Design Note

Response to Consultation on Application Number: 2017/90620 by Paul Farndale

This design note serves to provide a response to the comments provided by Paul Farndale on 27 March 2017. For completeness the original comments are listed above each response.

Title
FLOOD MODEL DRAWING

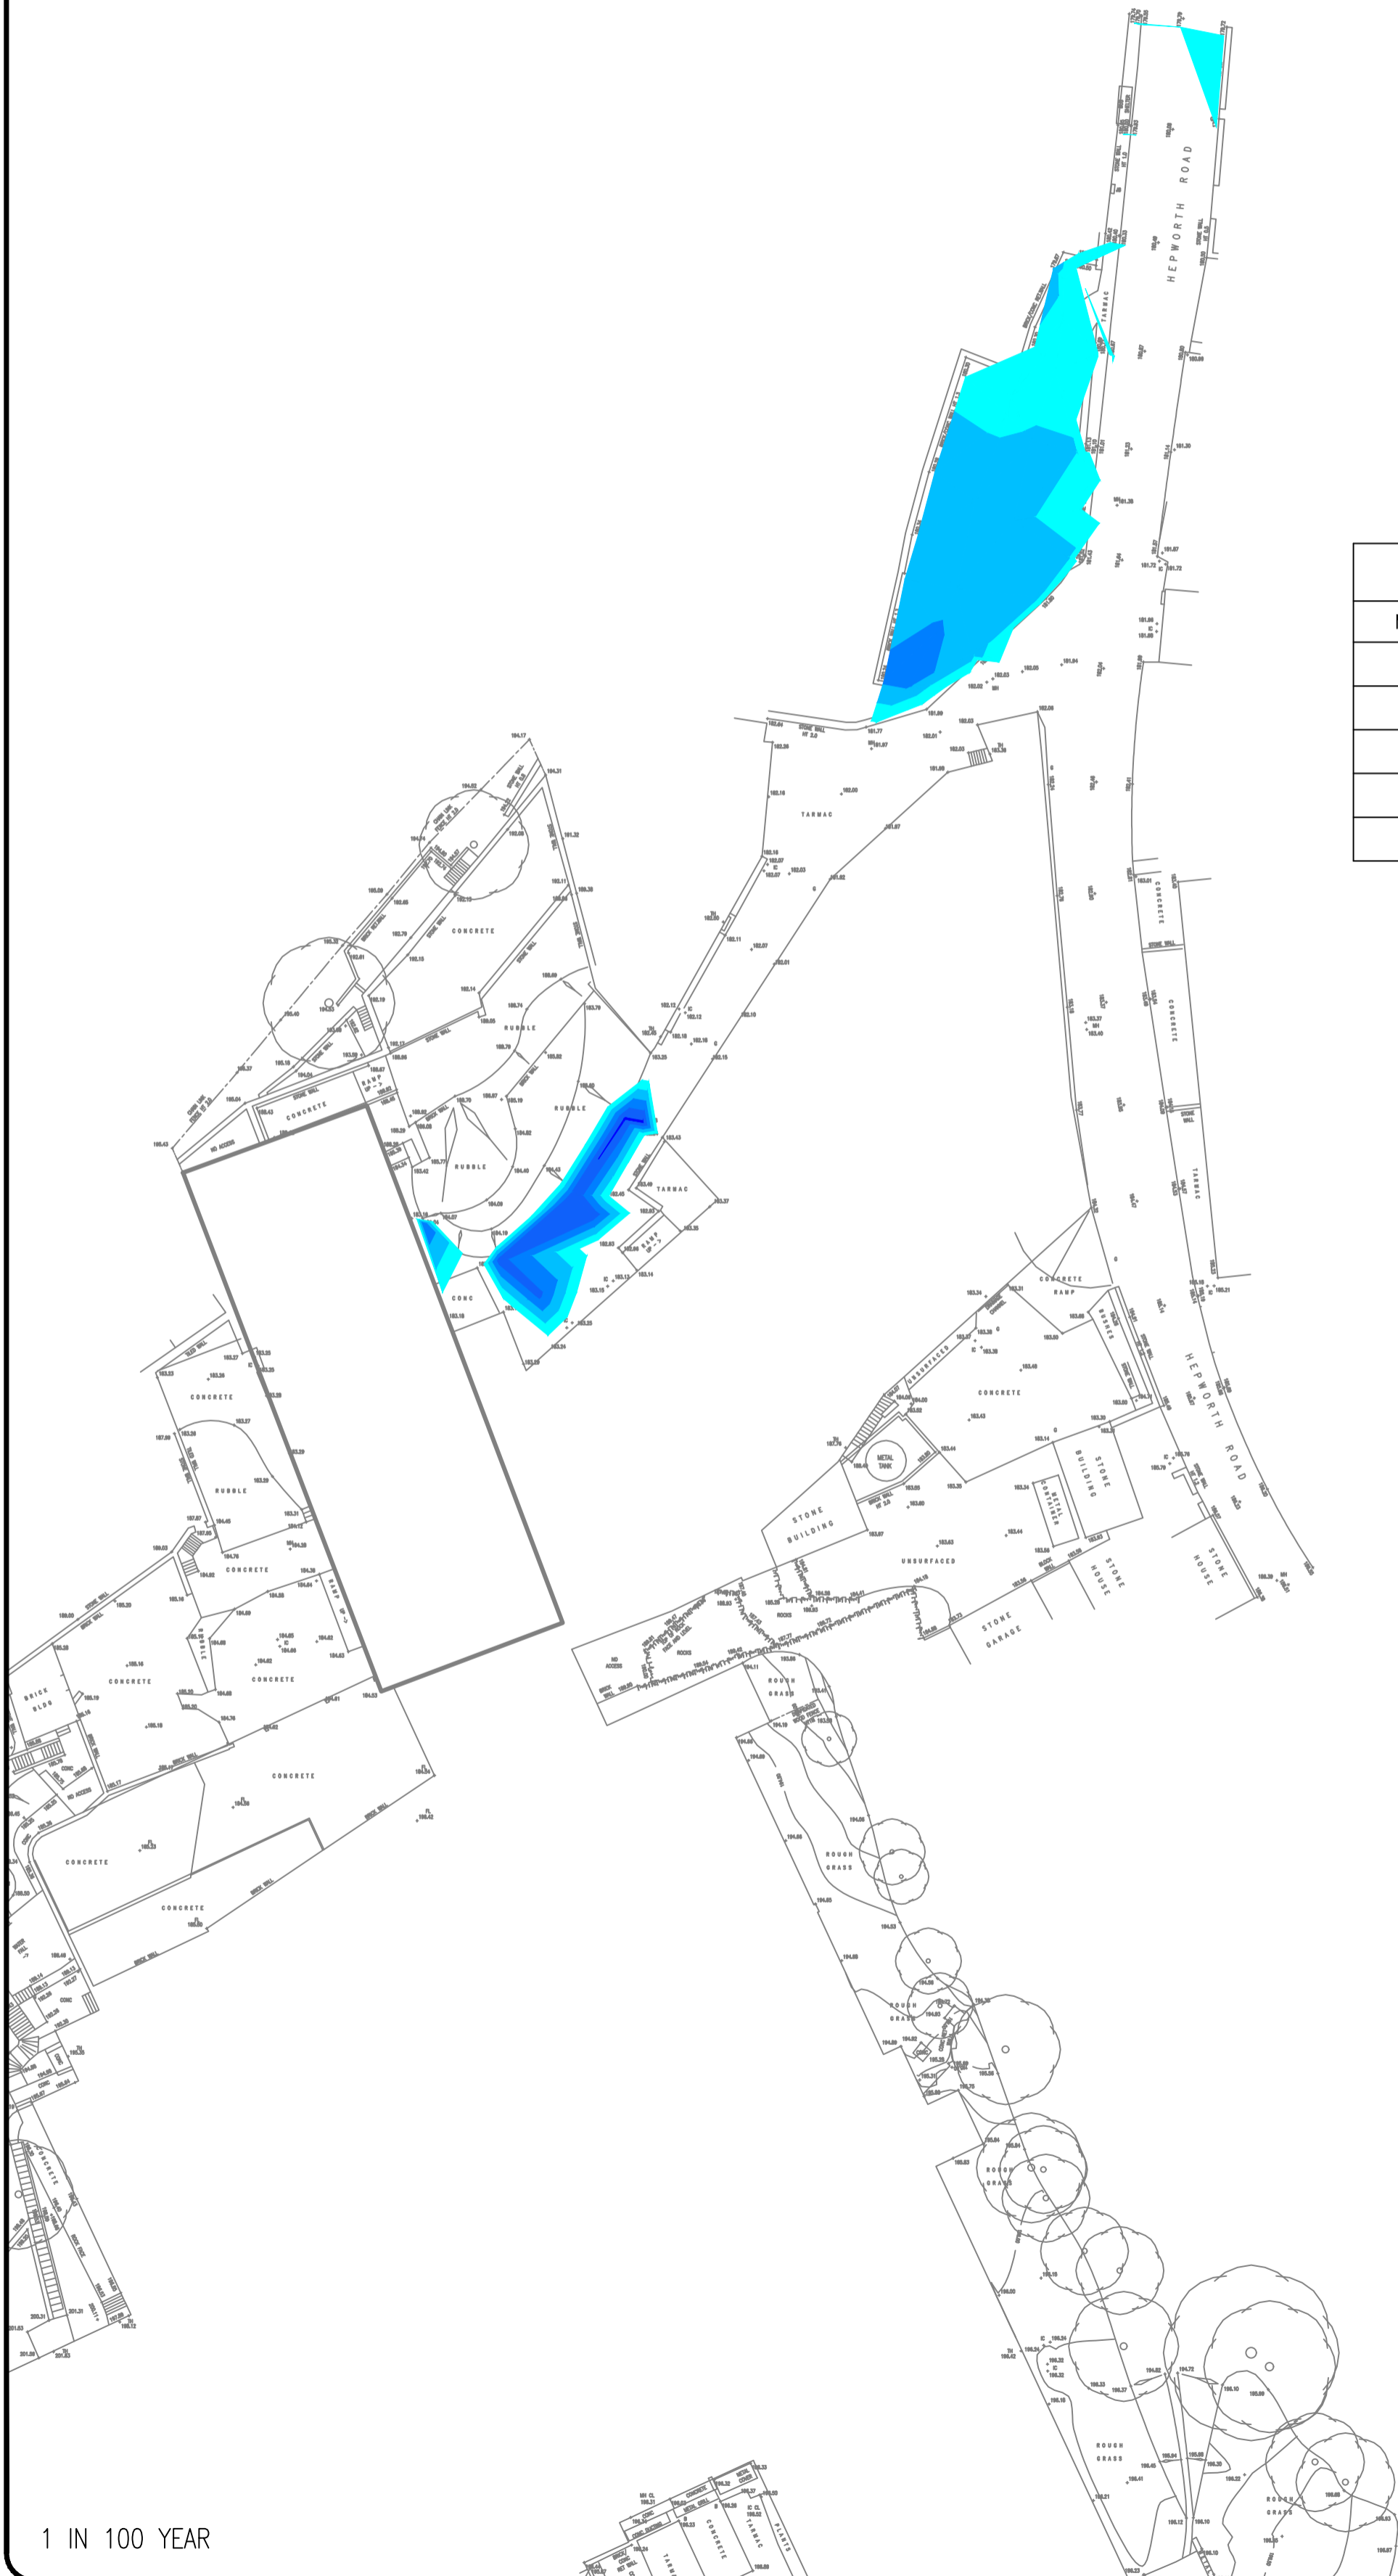
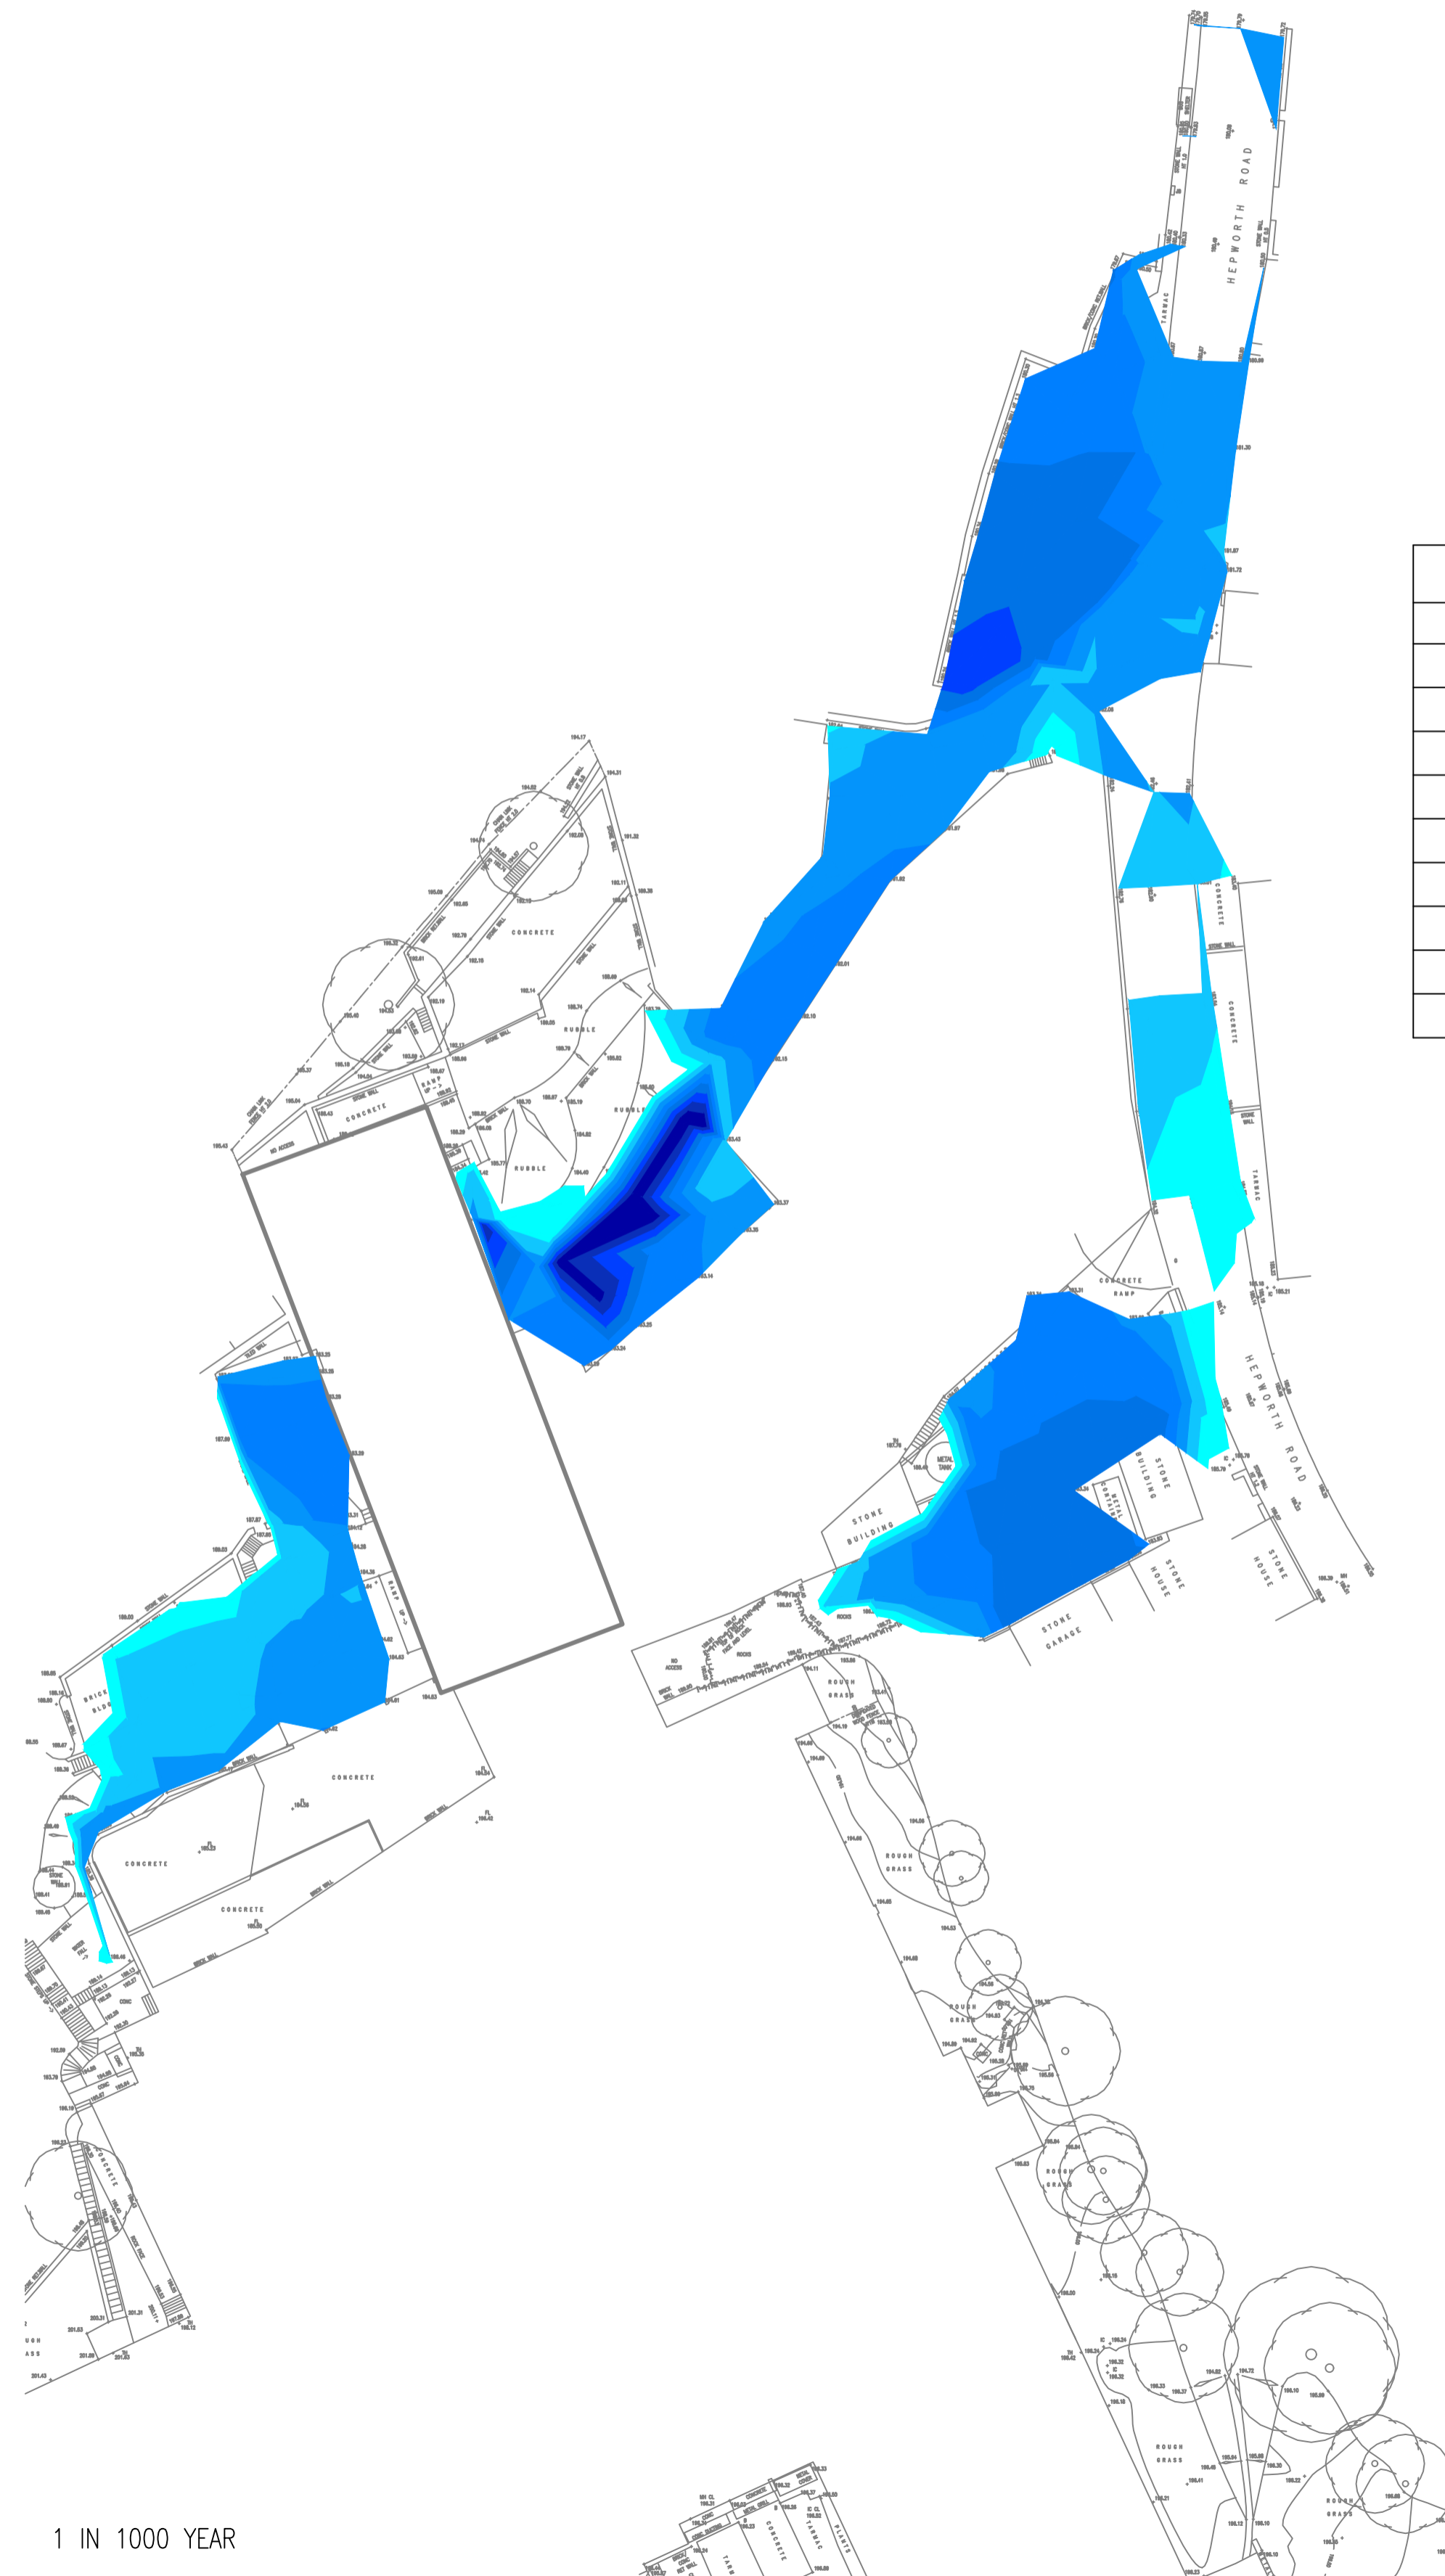
Existing topography and a discussion of overland flow routing within the Flood Risk Assessment should inform any proposed layout so exceedance flows and blockage scenarios utilise road networks and public open spaces and avoid the use of curtilage, i.e. demonstrate how risk is to be avoided.

For surface water exceedance events and blockage scenarios we are concerned that properties should not be located in low spots and that road networks and public open spaces are used to convey water safely off site.

Overland Flood Flow Routing has been considered at the earliest opportunity. The current flood flow strategy sketch is illustrated in figure 1.

Overland Flood Flow Routing has been considered at the earliest opportunity. The current flood flow strategy sketch is illustrated in figure 1.
